RE: New Public School in Googong SSD RFI (25 October 2021)

Reference is made to the response submissions from the Queanbeyan-Palerang Regional Council and public submissions made through the Planning Portal (as at 1 November 2021) with respect to SSDA submissions for the new school in Googong (Reference SSD – 10326042).

Table 1 QPRC Supplementary Submission 25 October 2021 (Council Reference PR.2021.1029)

Figure 16: Kiss & Ride Locations

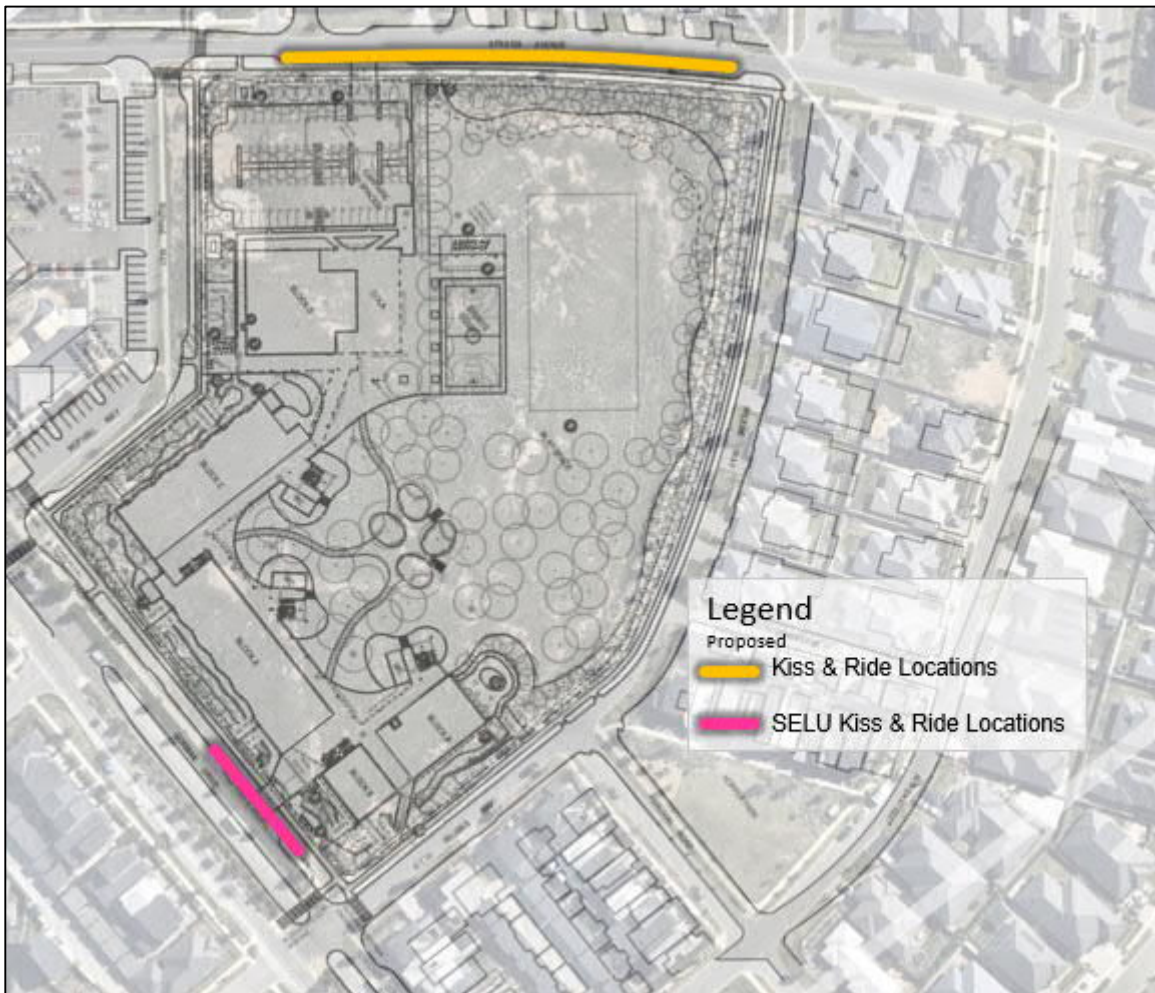
2	<p>From QPRC submission on EIS exhibition relating to the proposed inclusion of Kiss and Ride facilities on Gorman Drive.</p>	<p>In relation to the arrangement of SELU parking, the management of the SELU parking and manner in which the need for the parking is subject to the development of suitable management protocol with the appointed school principal as part of the School Travel Plan preparation process.</p>

<p>“Firstly, six of these spaces are located on Gorman Drive, which are proposed to service the Special Education Portion of the school which is likely to be a smaller student population that likely need longer times for this operation. Council staff do not consider this to be “best design practice” creating a conflict with passenger vehicles attempting to pull in and potential queuing adjacent to buses attempting to leave.”</p> <p>The space in question above has been reduced to three 15 min parking spaces and two accessible spaces to be used if needed for SELU. However, there is no mention of how the “if needed” provision would be enforced under an STP. Whilst some changes to the arrangement have been made, Council’s original commentary on the EIS regarding the suitability of parking spaces in this area is still generally relevant. Development Engineering would support requesting a condition of the SSDA that any STP should be approved by Council prior to adoption.</p>	<p>It is anticipated that a permit system in conjunction with parking restriction signage will be developed to ensure the managed use of the spaces concerned by SELU meet the operational requirements of the School in consultation with Council.</p> <p>It is further noted that SELU students can be dropped off using the Wilkins Way Kiss and Ride, with the spaces along Gorman Drive intended for families that require additional time for pick-up / set-down.</p>
